Development Facilitation Team (DFT) – Review Comments

Project No: PR-2020-004218 Date: 7/10/2024 Agenda Item: #2 Zone Atlas Page: F-17

Request: Remodel of existing Chick-Fil-A consisting of drive-thru widening, parking modification, and striping.

Application For: SI-2024-00923 – SITE PLAN DFT

TRACT D-1-A
MONTGOMERY PLAZA
BK 2011C PG 135
ZONE: MX-M
LAND USE: BANK

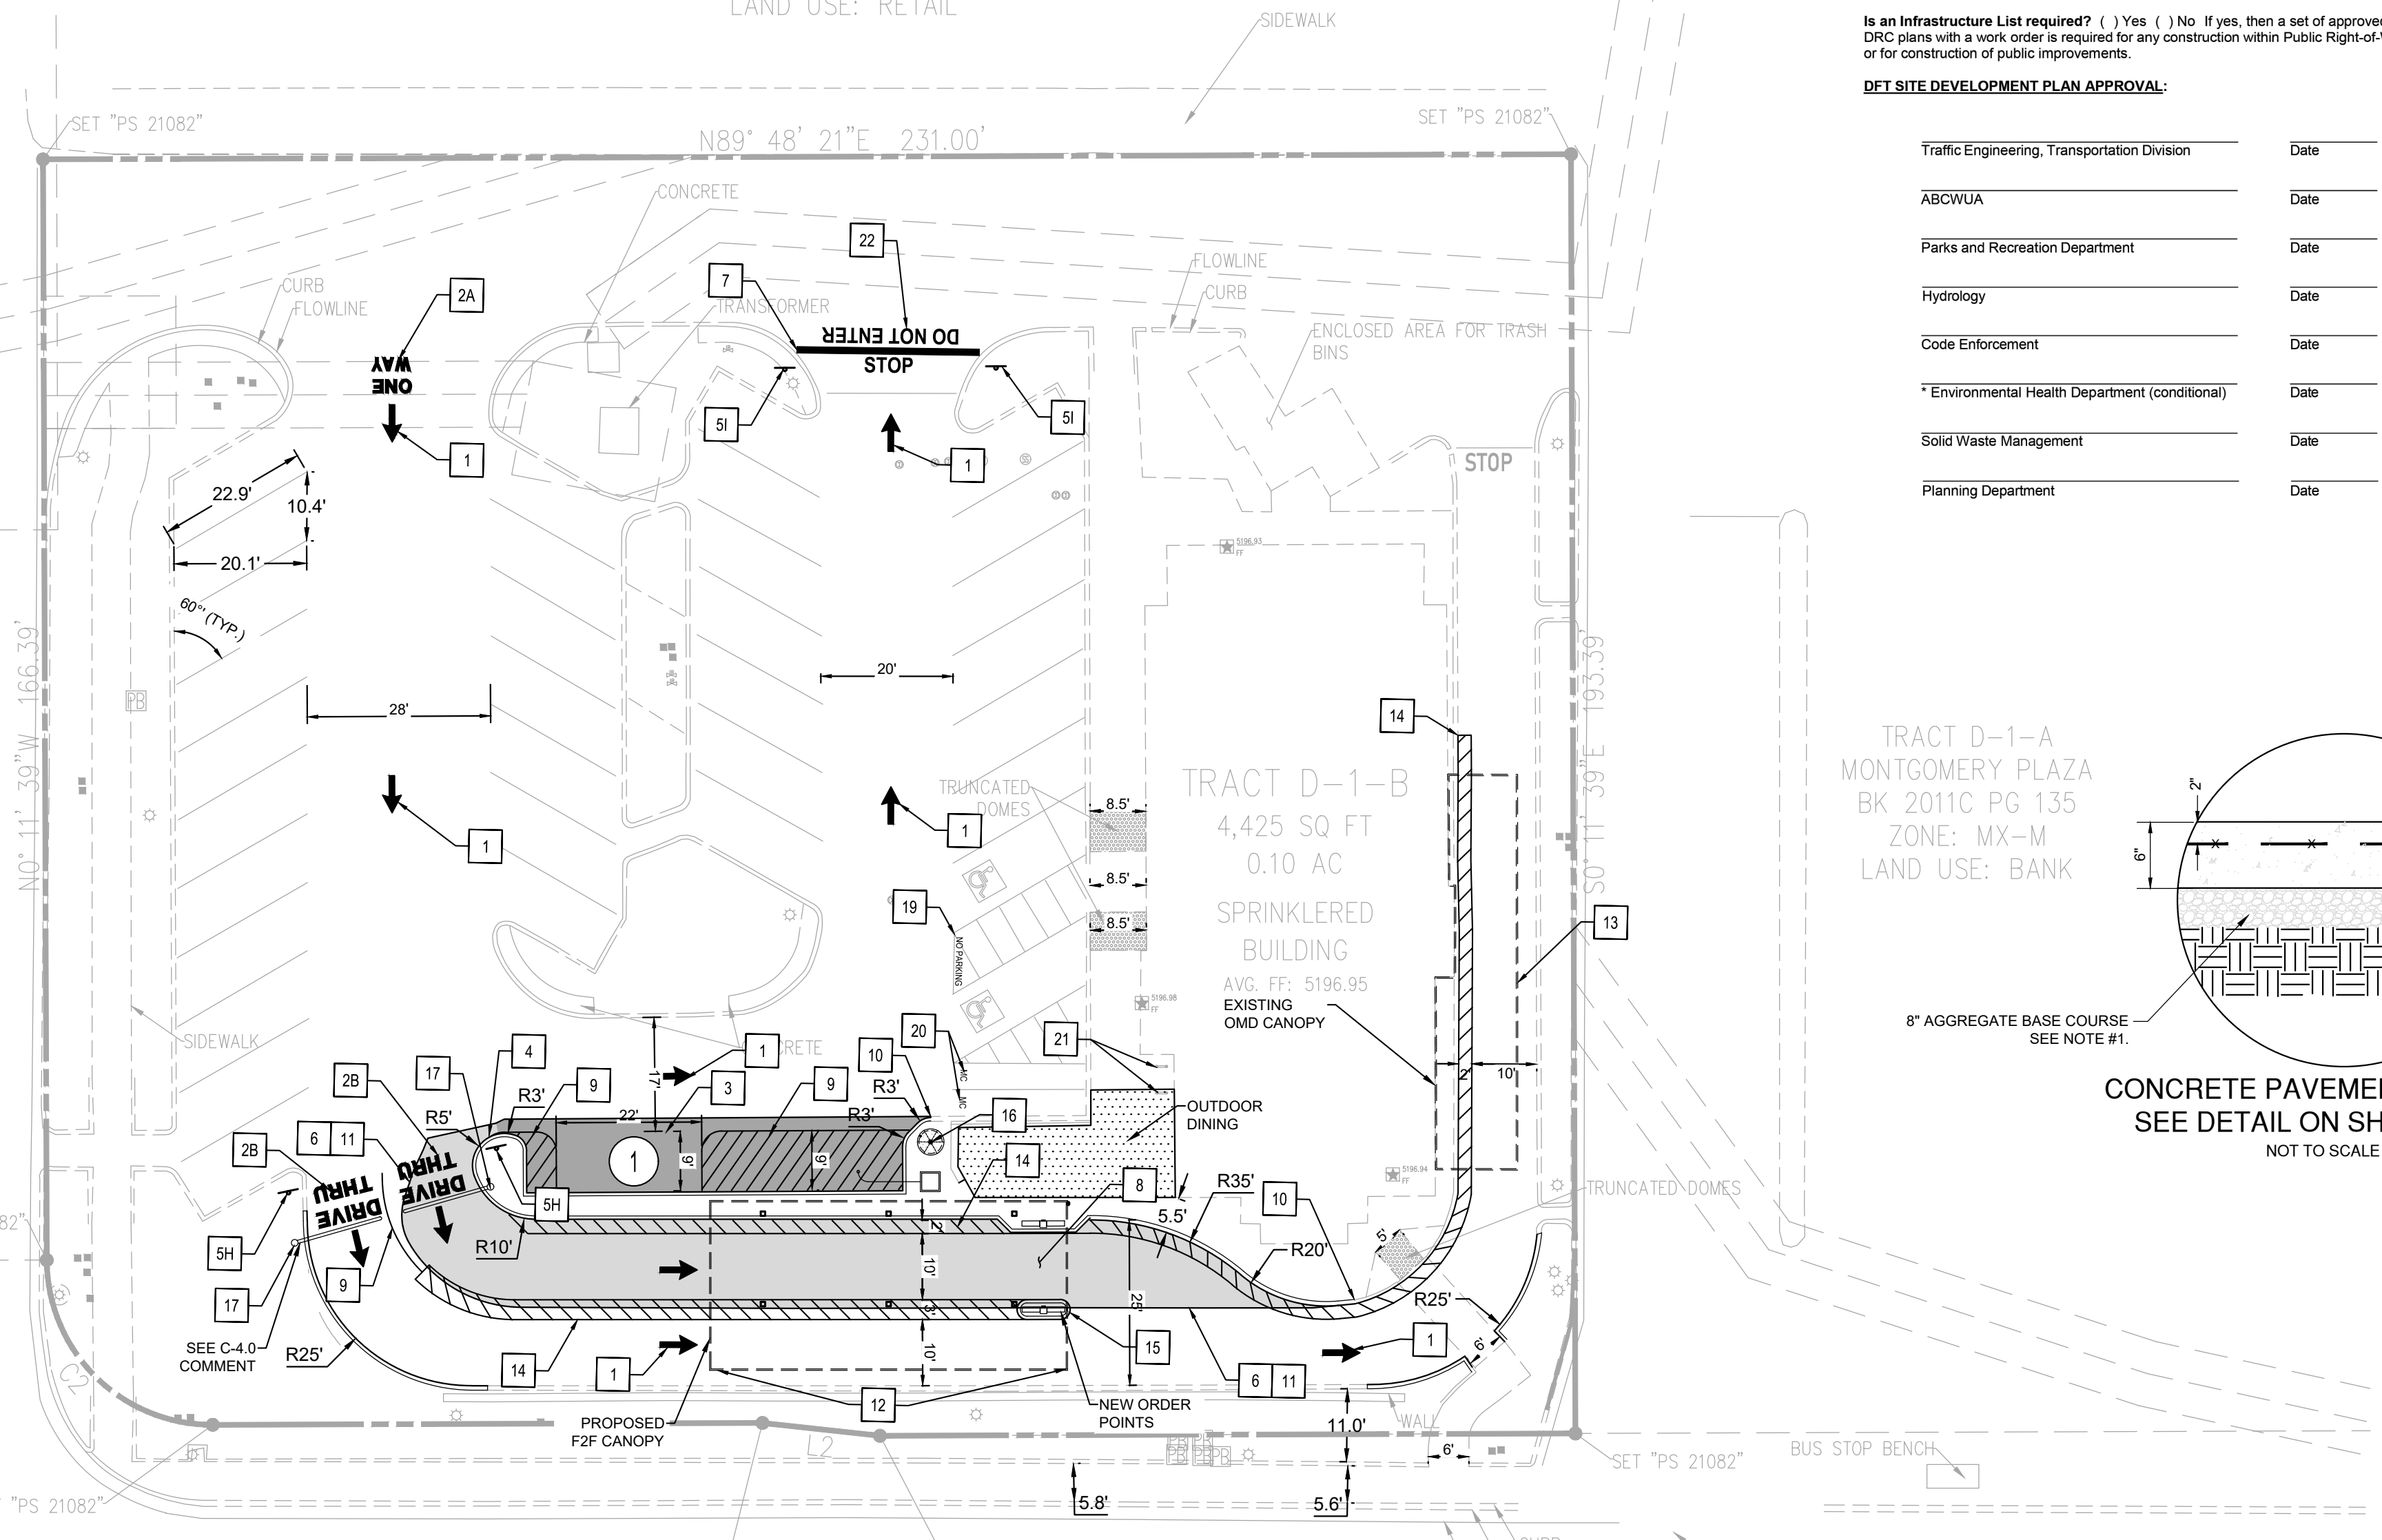
1. Parking spaces for Motorcycles are mislabeled on Sheet C-2.0 as # 19 on site plan map (should be 20).

01 IRRIGATION PLAN UPDATES

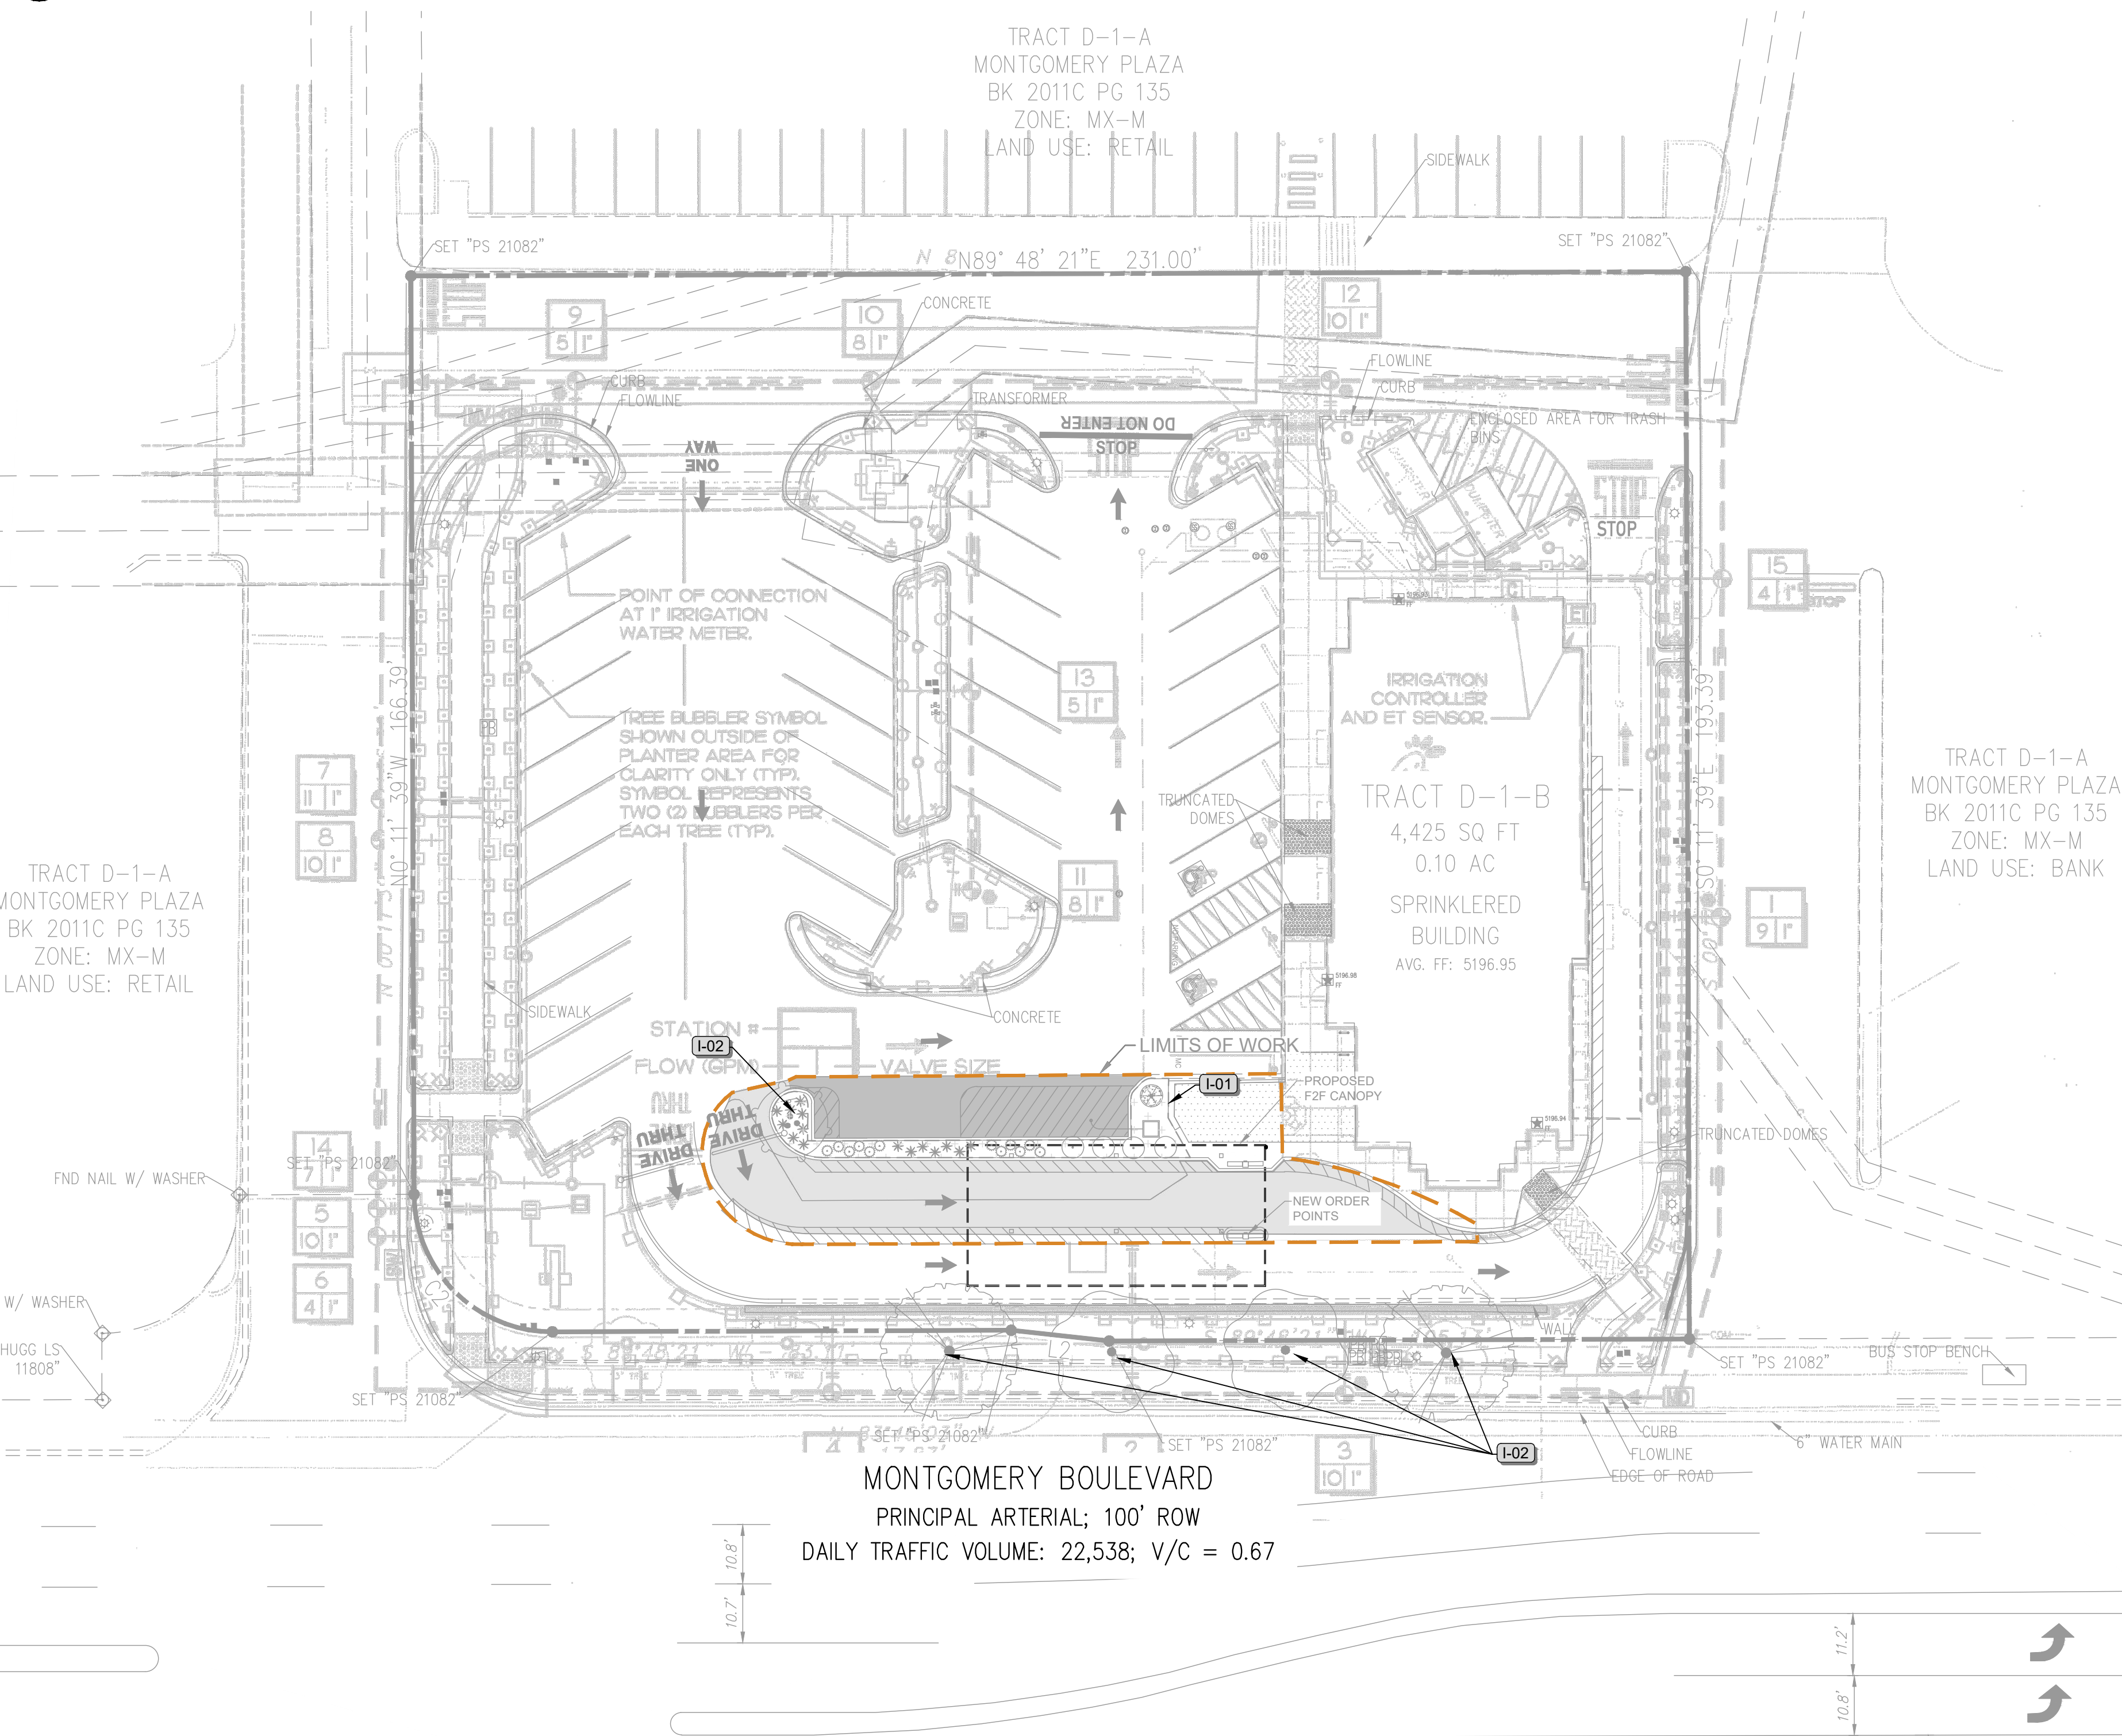
- Per City Forester's comment, replace the plum tree with a different tree species such as Pink Pom Poms Redbud, Russian hawthorn, Paul's Scarlet Hawthorn, and Golden rain tree.

- Per the landscape plan approved with the site plan, it appears that some vegetation is missing from the site, including 4 street trees along Montgomery Boulevard. All missing or dead plant species must be replaced. Per City Forestry avoid using Ash trees. Following trees are better options and are recommended by the City Forester:
 - Allee Elm (*Ulmus parvifolia* 'Emer II)
 - Accolade Elm (*Ulmus davidiana* var. *japonica* 'Morton')
 - Hackberry (*Celtis occidentalis*)

- Per 5-6(F)(2)(a) General, at least 10 percent of the parking lot area of lots containing 50 or fewer spaces, and at least 15 percent of the parking lot area of lots containing 50 or more spaces, shall be landscaped. Calculations must be shown on the Landscape Plan.

- One (1) tree is required per 10 parking spaces. 7 trees are required and 7 trees are being proposed.
- No parking space may be more than 100 feet in any direction from a tree trunk. Compliant.
- At least 75 percent of the required parking area trees shall be deciduous canopy-type shade trees, capable of achieving a mature canopy diameter of at least 25 feet. Calculations must be shown on the Landscape Plan.

- The minimum size of tree planters within off-street parking areas shall be 60 square feet per tree. This requirement may be reduced to 36 square feet if the surface of a parking or vehicle circulation area abutting the tree planter is of a permeable material and, combined with the tree planter area, meets the 60 square foot per tree requirement. Calculations must be shown on the Landscape Plan.

WILL COORDINATE WITH LA TO CONFIRM OK

WILL CALCULATE/ COORDINATE WITH LA TO CONFIRM OK

WILL CALCULATE/ COORDINATE WITH LA TO CONFIRM OK

4 TREE PLANTING DETAIL
 1" = 50' P-CH2-30

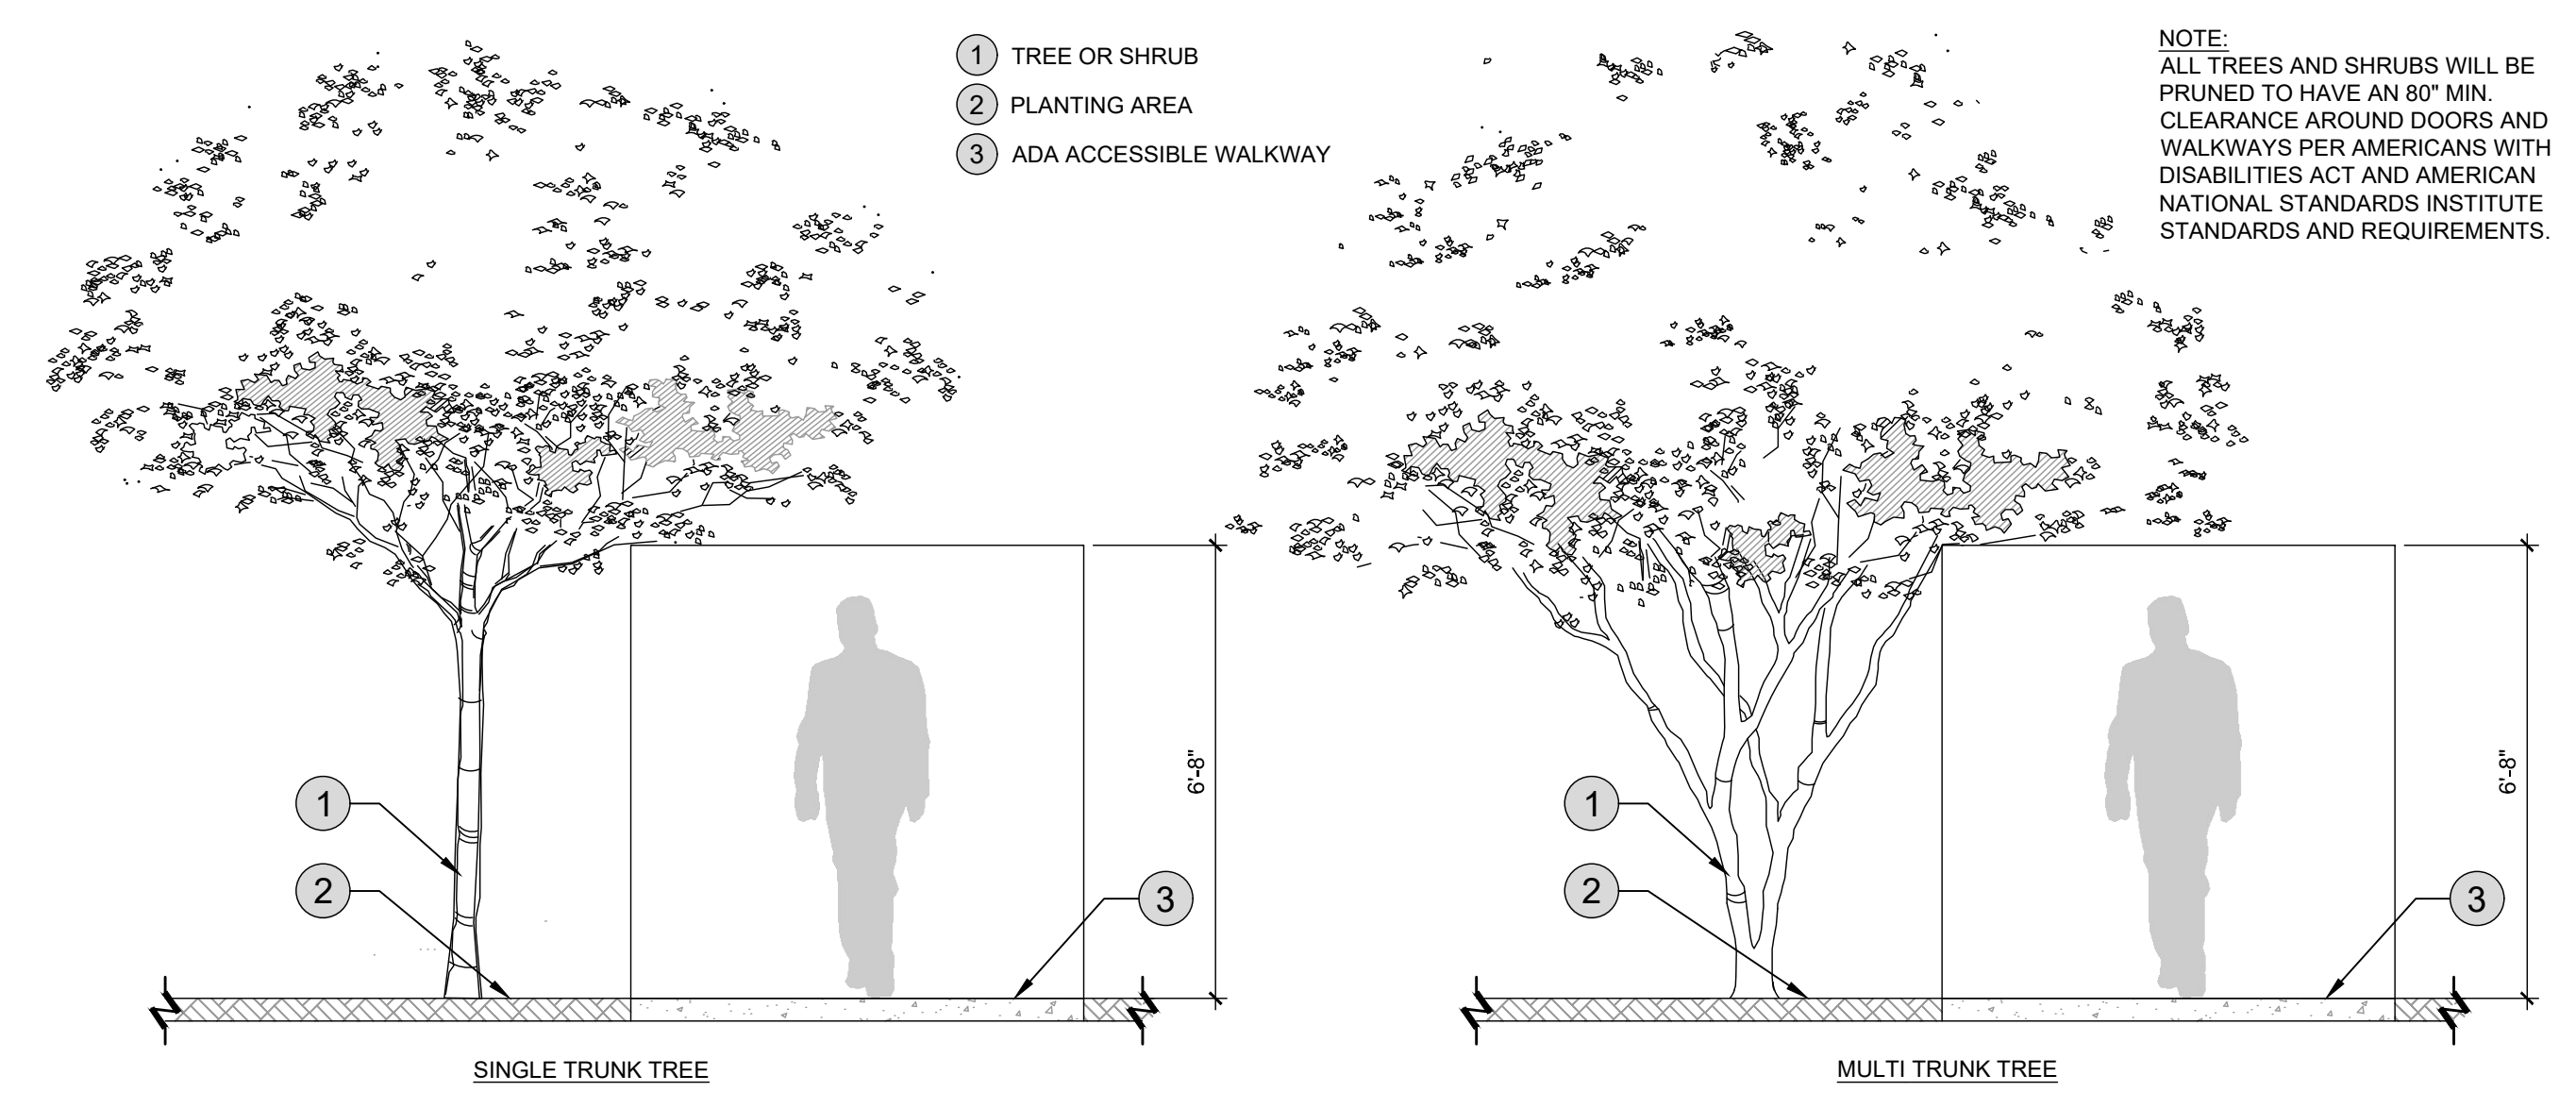
- Per 5-6(C)(5)(e) Organic mulch is required as ground cover under trees within a 5-foot radius around the tree trunk, but not directly against the trunk. In these areas, weed barrier fabric is prohibited. (See figure below.)

A tree planting detail must be added to the Landscape Plan to reflect this requirement.
